**Consultation Response from KC,  
Highways Development Management**

**2024/90170 Unit 1b, Centre 27 Business Park, Bankwood Way, Birstall, Batley, WF17 9TB**

**Advertisement Consent for erection of illuminated and non-illuminated signs**

**Date Responded: 4-3-2024.**

Unit 2 Centre 27 Business Park, Bankswood Way, Birstall

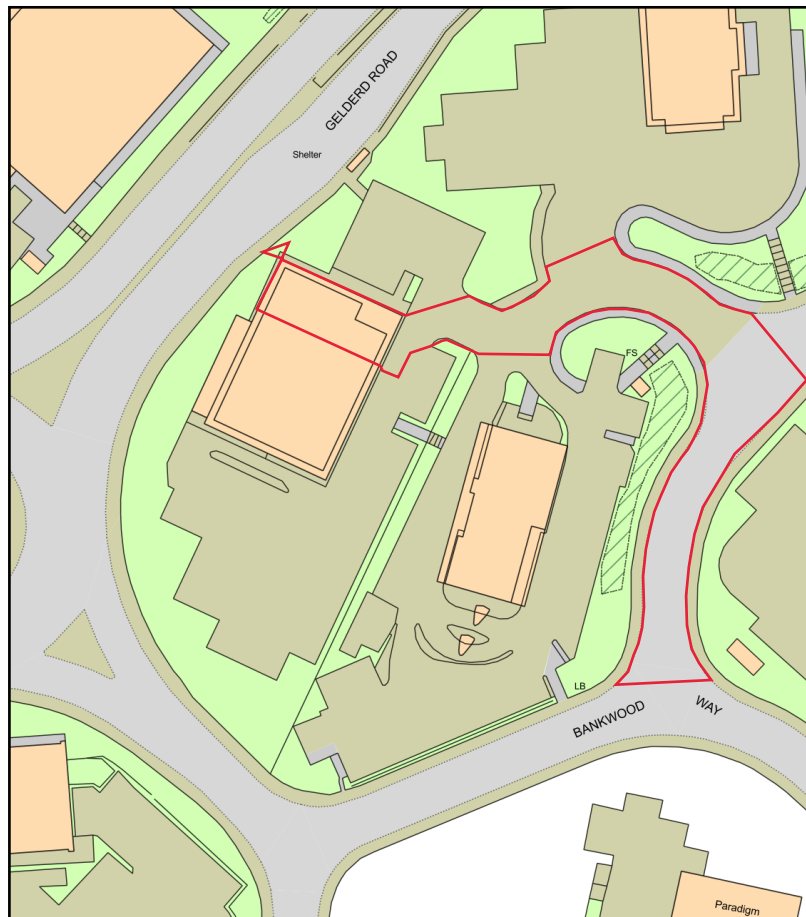
The location plan (drawing number RPEN/S6422/01) is not sufficiently detailed to enable the exact location of the proposed totem pole to be determined. The layout of Geldard Road needs to be properly shown including the footways, verges and other nearby signs and street furniture.

The applicants should also confirm their proposals for the existing Starbucks totem pole and sign.
